Alterations and extension to conservatory, first floor side extension, balcony area at first floor, alteration of windows on rear first floor to create Juliet balconies, balcony doors & new window on ground floor side elevation.

Anchors Cast 2 Fosters Close Rustington

Thank you for your internet representation made on 24th July 2019 which has been recorded as '**an objection**' with the comments as follows:

The Conservatory Alterations

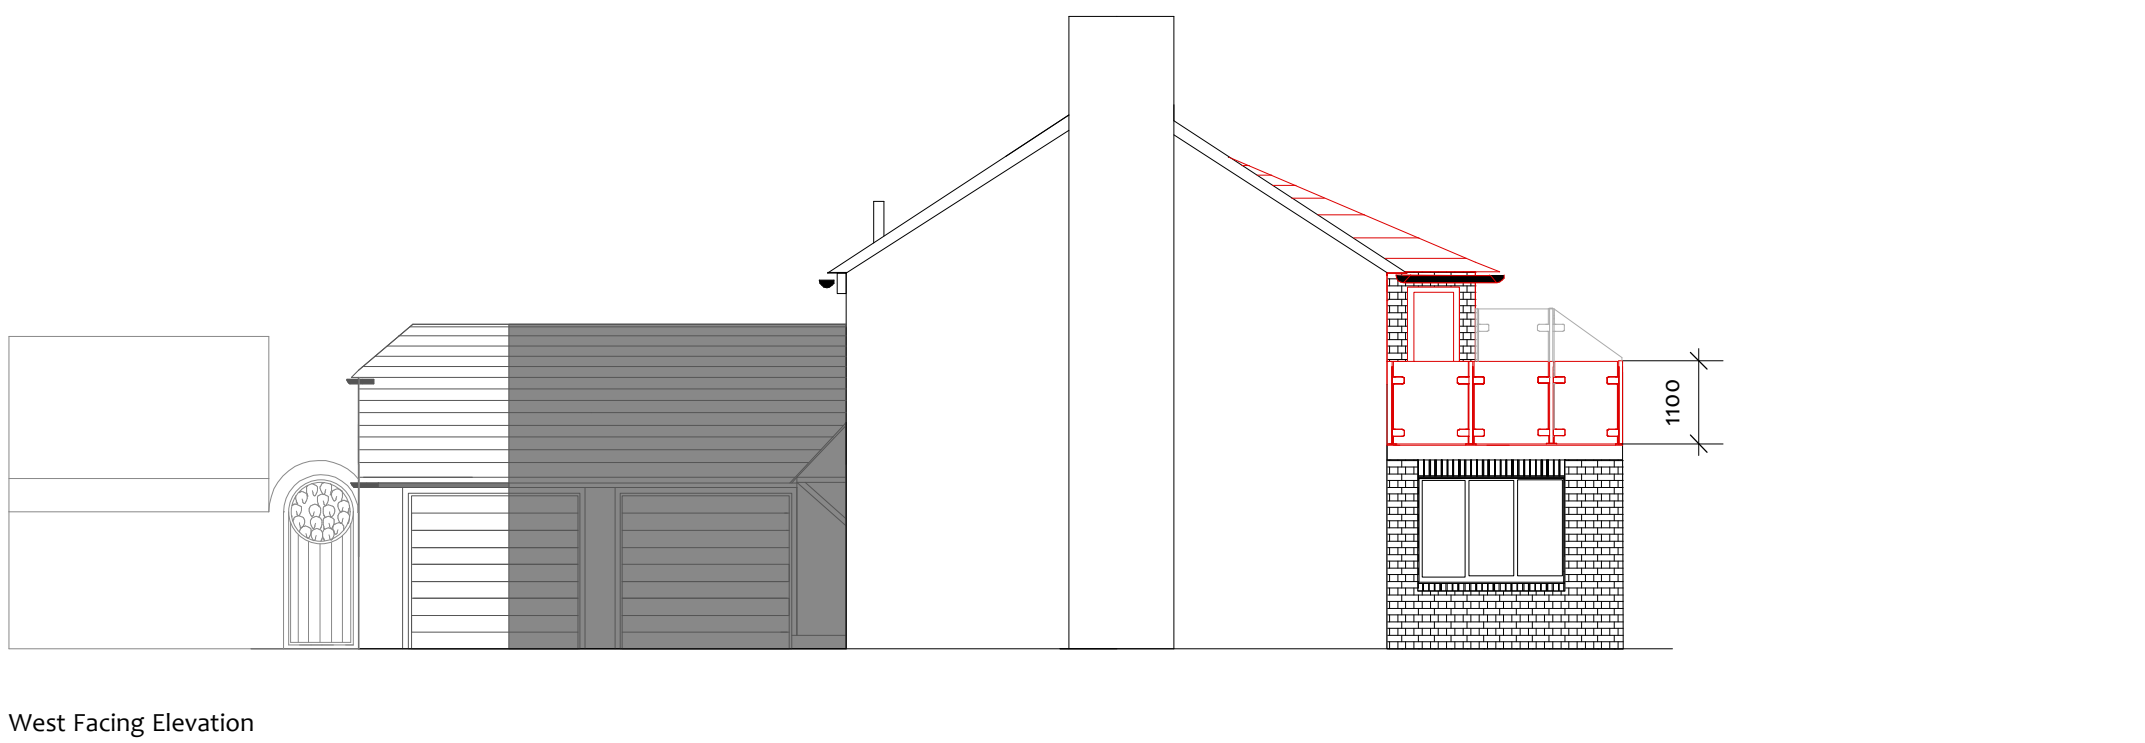
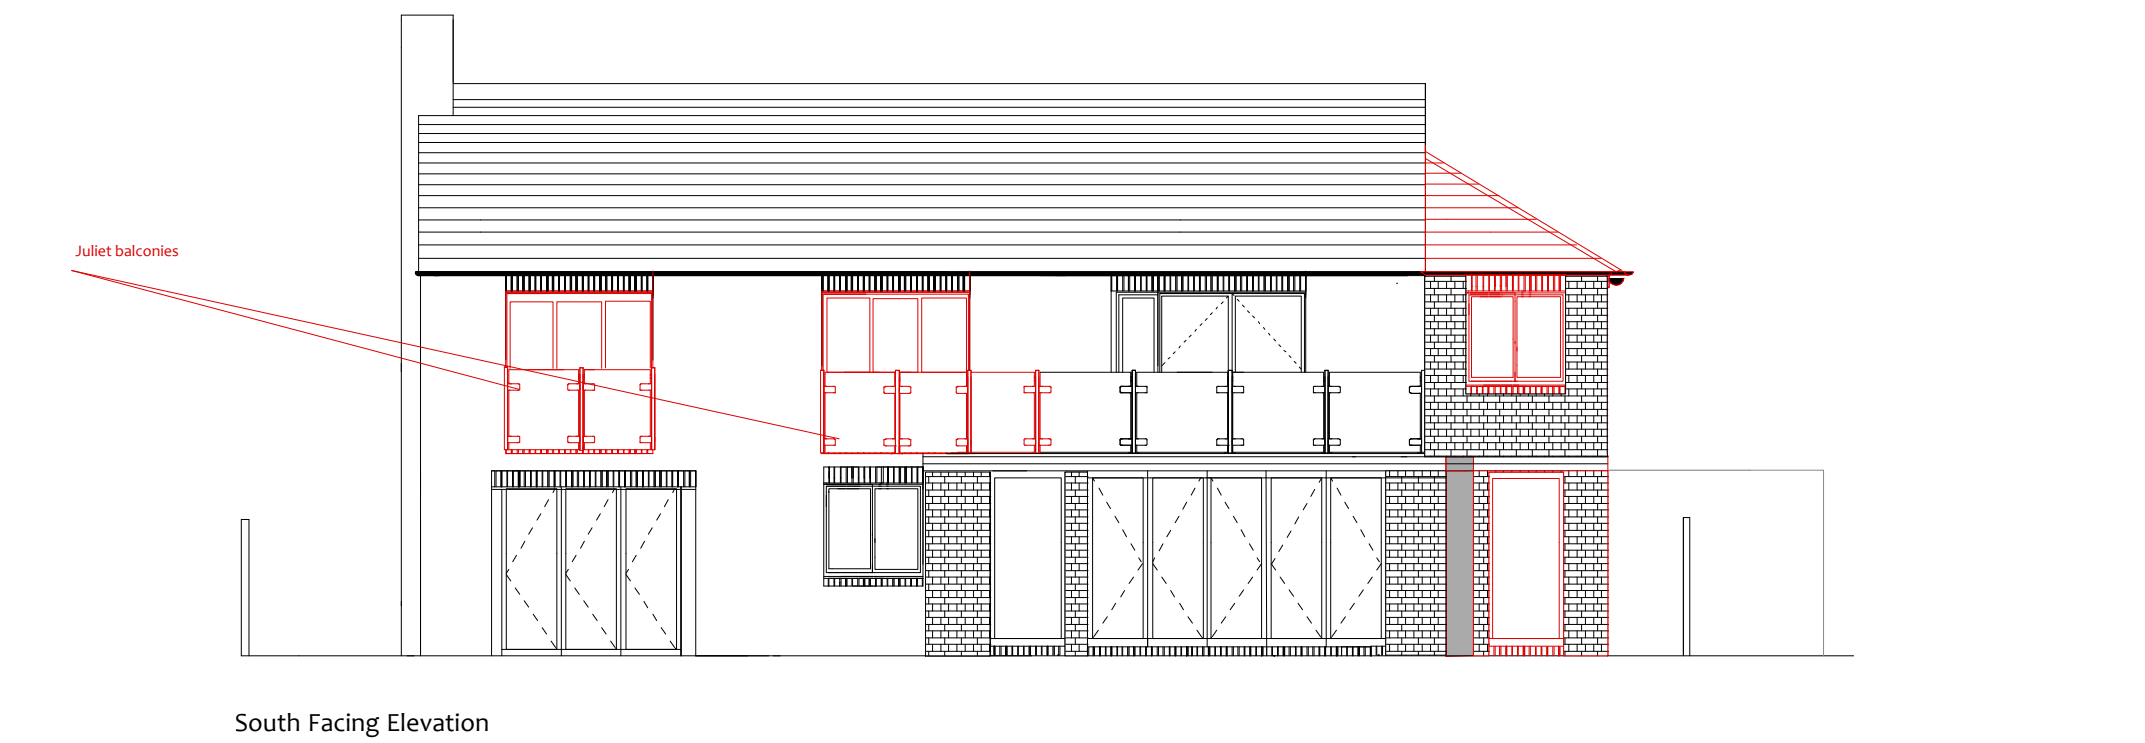
The Directors of Fosters Management Ltd, who own the Freehold of the block of 10 leasehold flats to the east of 2 Fosters Close, still object to the revised plans for this application, being drawing title "proposal plans 15" and number "IA/E/DJL/0408". Their objection is that, although the proposed extension of the reading room has been reduced from the original plans, it still extends out south beyond the existing building line which does not meet with the approval of Fosters Management Ltd.
